Rezoning Transportation Analysis

Petition Number: 2023-030

Date	Description
5-24-23	First Review (DR)

## Rezoning Site Plan

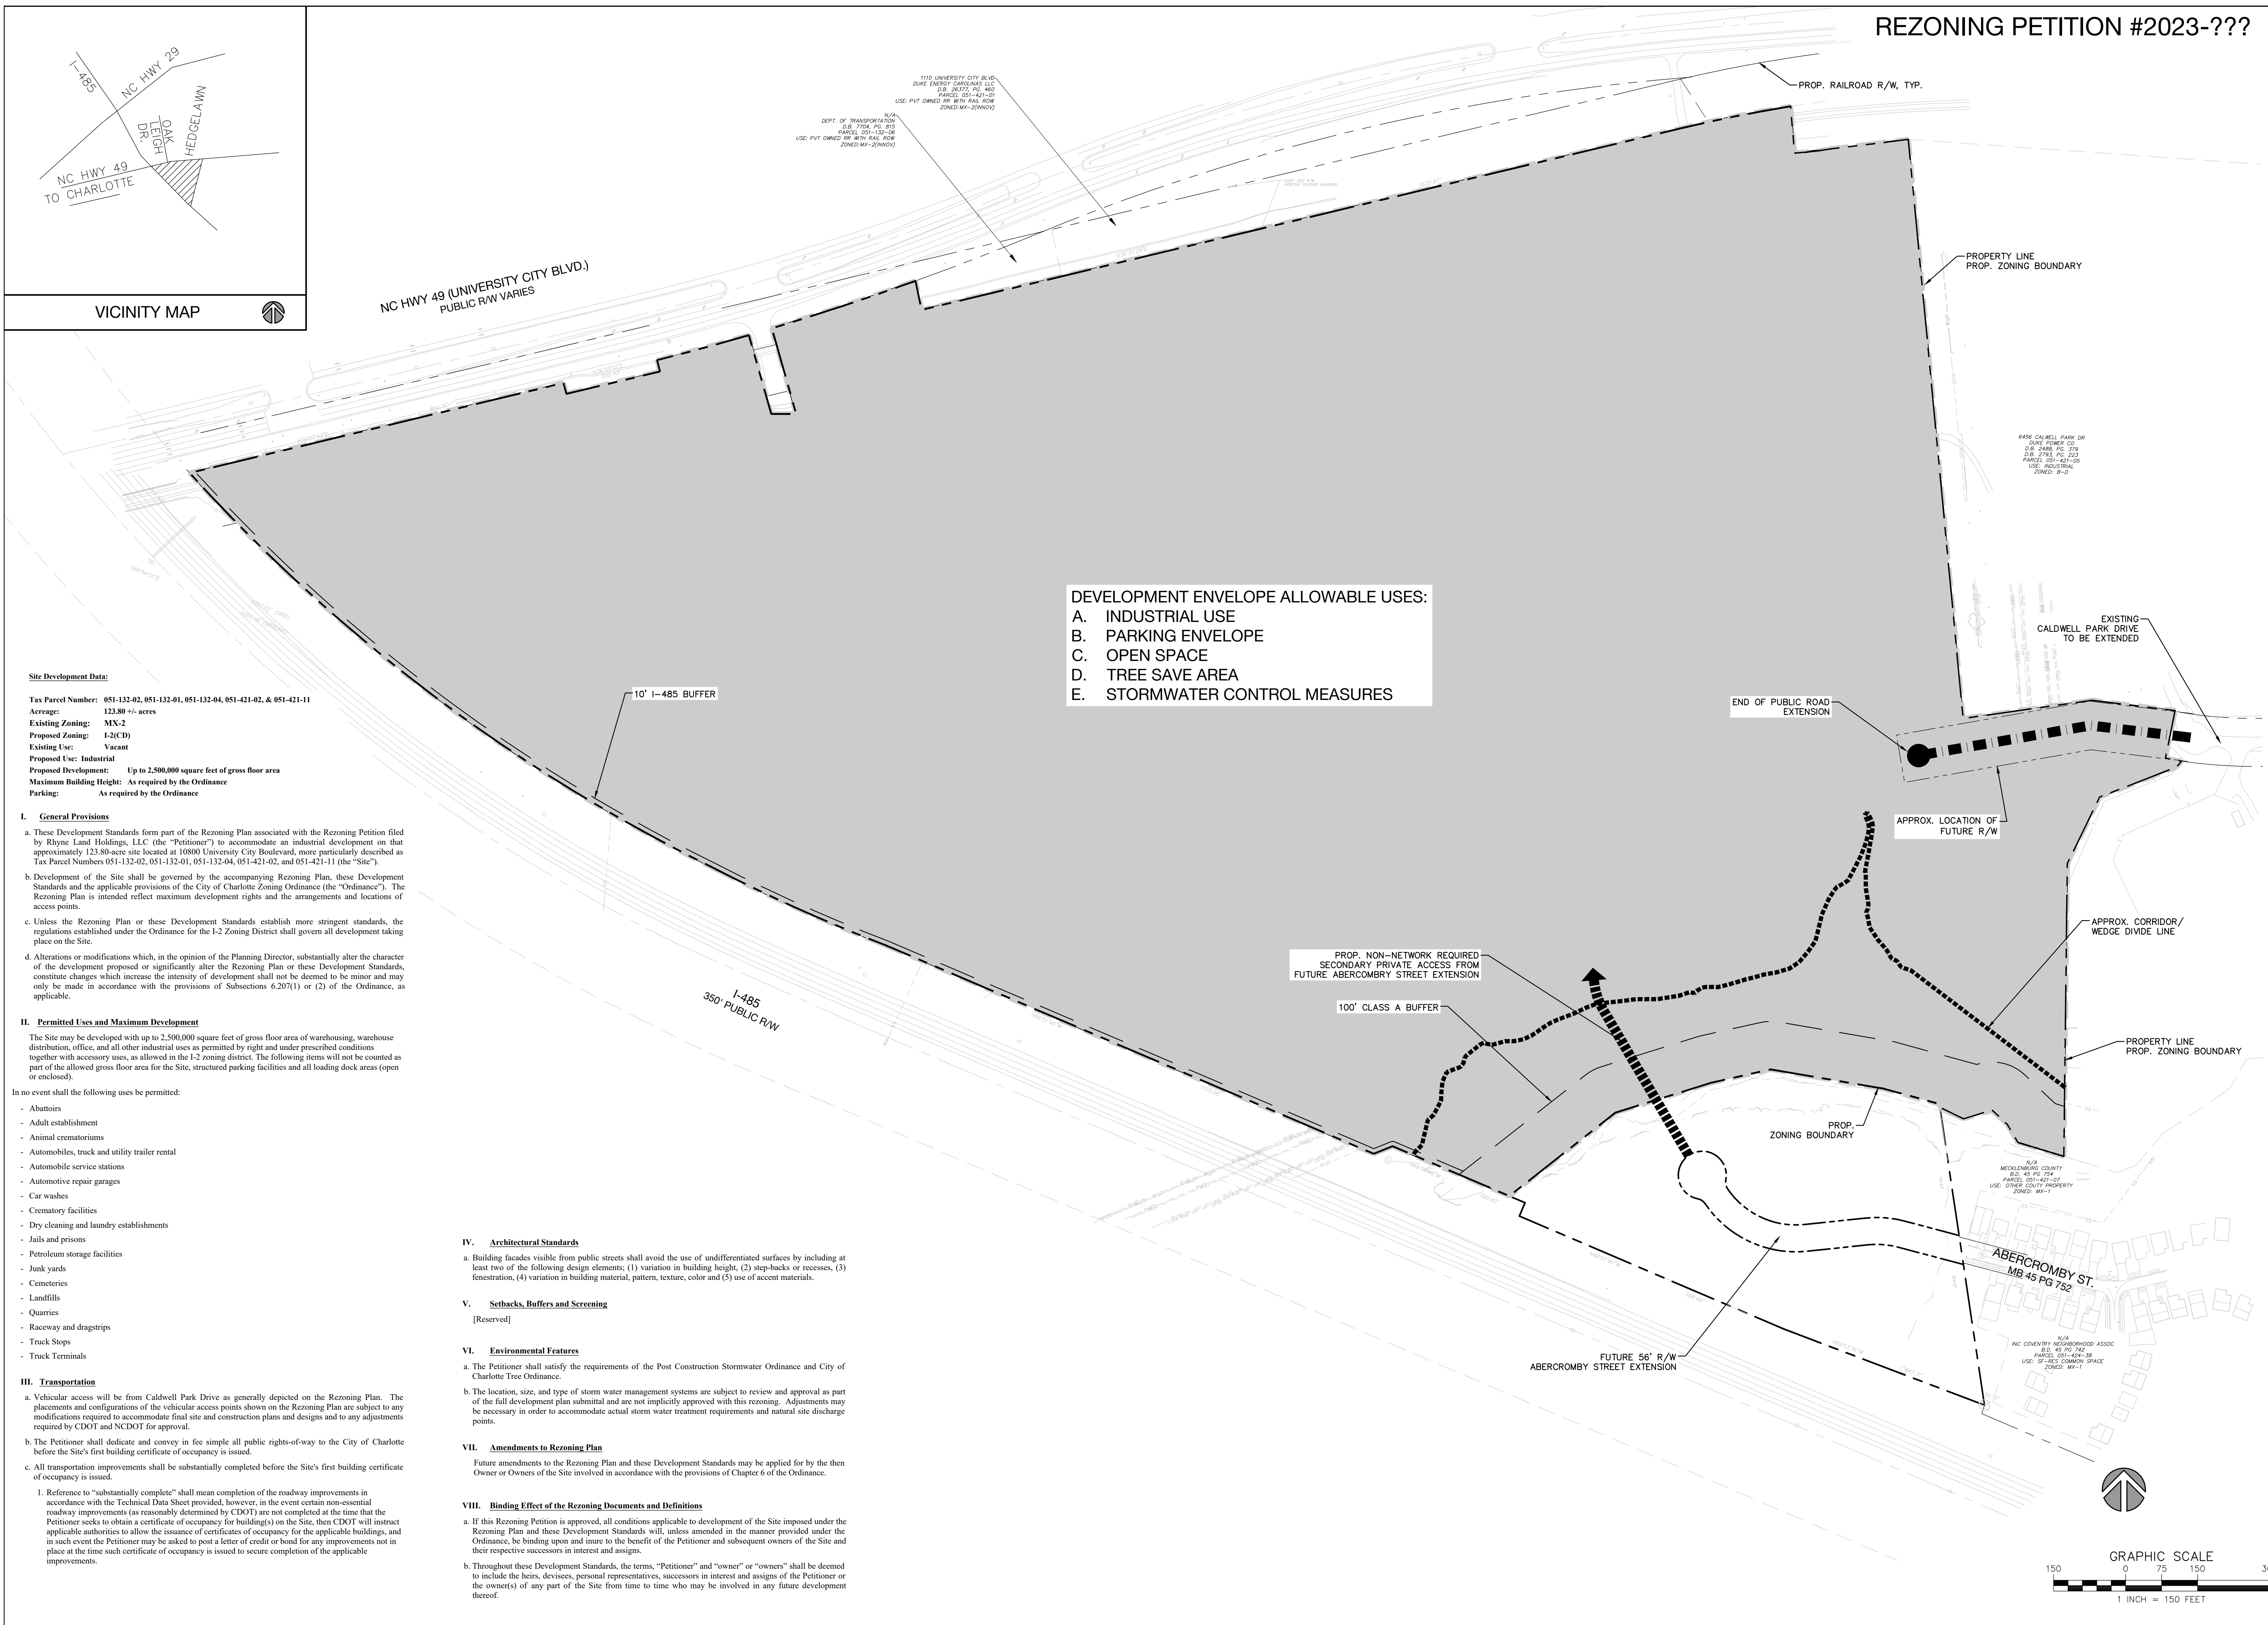
2. Remove the connection to Abercromby Street.
3. Add conditional note(s) committing to extend Caldwell Park Drive and upgrading to a local industrial street standard to accommodate the increased truck traffic.

4. Add conditional note that petitioner shall construct bicycle facilities by installing a 12' multi-use path with an 8' minimum planting strip along Caldwell Park Road. The proposed multiuse path should be extended along the southern side of Caldwell Park Drive to the northwest corner of Parcel ID 05114117 owned by Mecklenburg County.

5. Add conditional note to dedicate greenway area on the south side of Back Creek Church Road extending the existing greenway to the right-of-way of Interstate-485. The multiuse path will provide a connection from the site to the Mecklenburg County Park (Caldwell Park).

6. Revise site plan and conditional note(s) to commit to construct an 8-foot planting strip, and 6-foot sidewalk along each side of the proposed local industrial street. The site plan shall label and dimension each item from the back of curb.
